RMS Ref: SYD12/01477/03
Department's Ref: SSD 5746

**EXPANSION OF EXISTING MAINFREIGHT WAREHOUSE AND DISTRIBUTION FACILITY AT
30-50 YARRAWA ROAD, PRESTONS**

RMS has reviewed the proposed expansion of the warehouse and distribution facility and has no objections to the proposal subject to the following conditions below:

### Truck Parking Management Plan

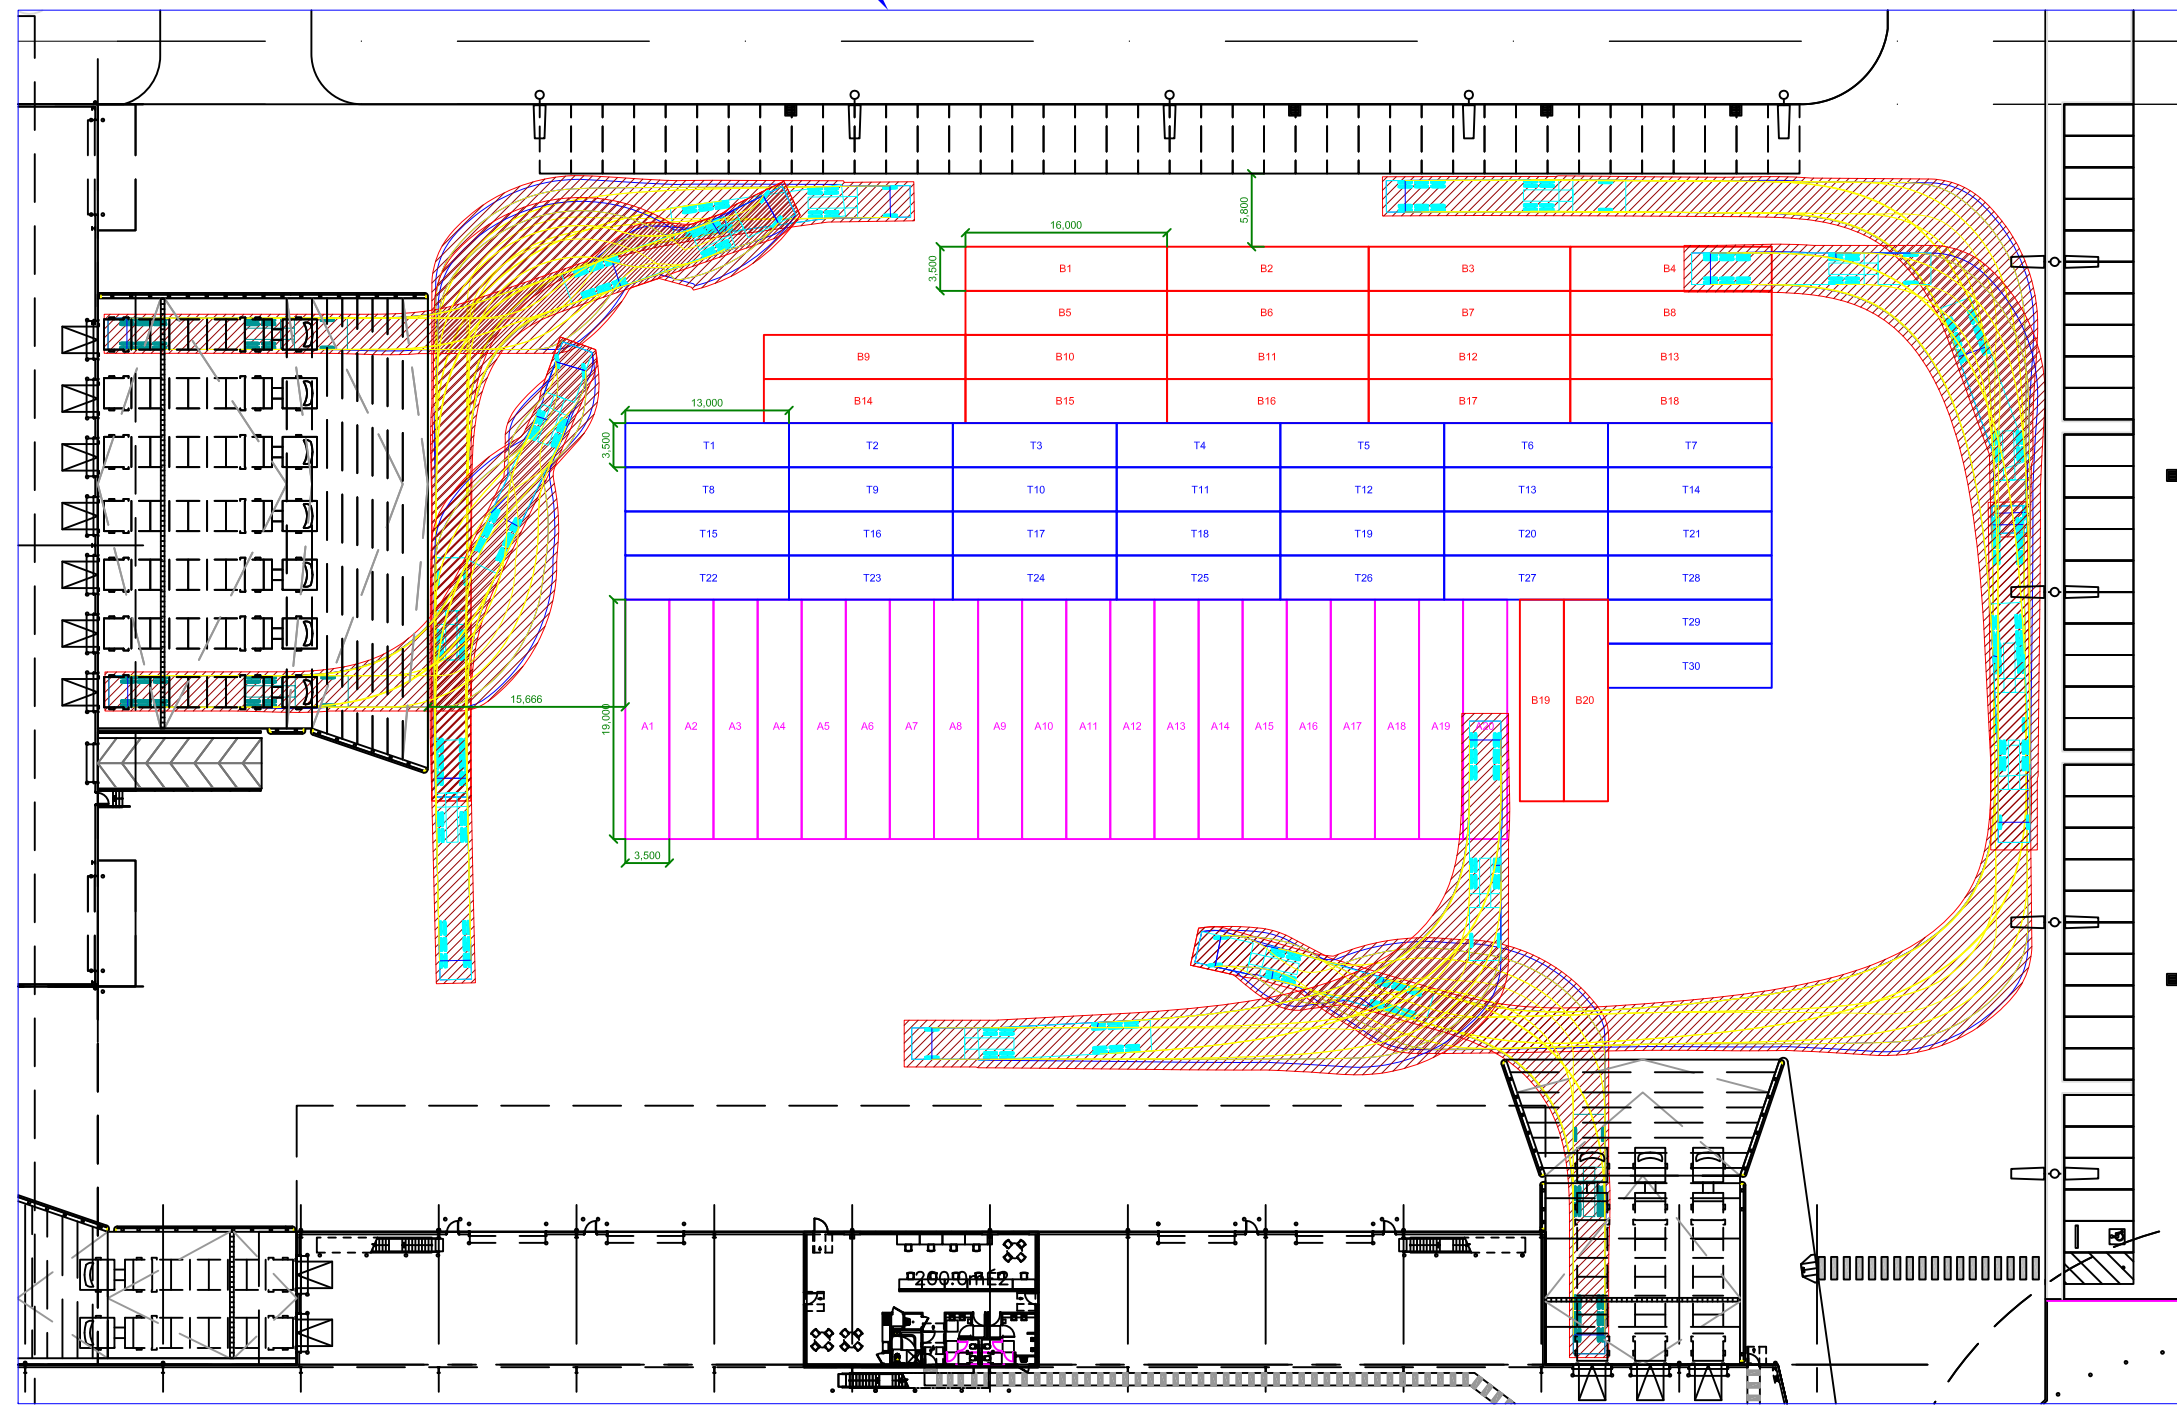
5. Heavy vehicle parking is to be in accordance with the Truck Parking Management Plan (TPMP) – Drawing No: TX.07; Dated: 08/04/13, depicted within Appendix C of the Traffix Traffic Impact Assessment report (12.424r01v3).

6. As the TPMP will result in stacked parking, such spaces will need to be managed in an orderly manner. To address the management of stacked parking, the proponent will need to

prepare and submit a Truck Operational Management Plan to the Department and Council for approval prior to the issue of an Occupation Certificate.
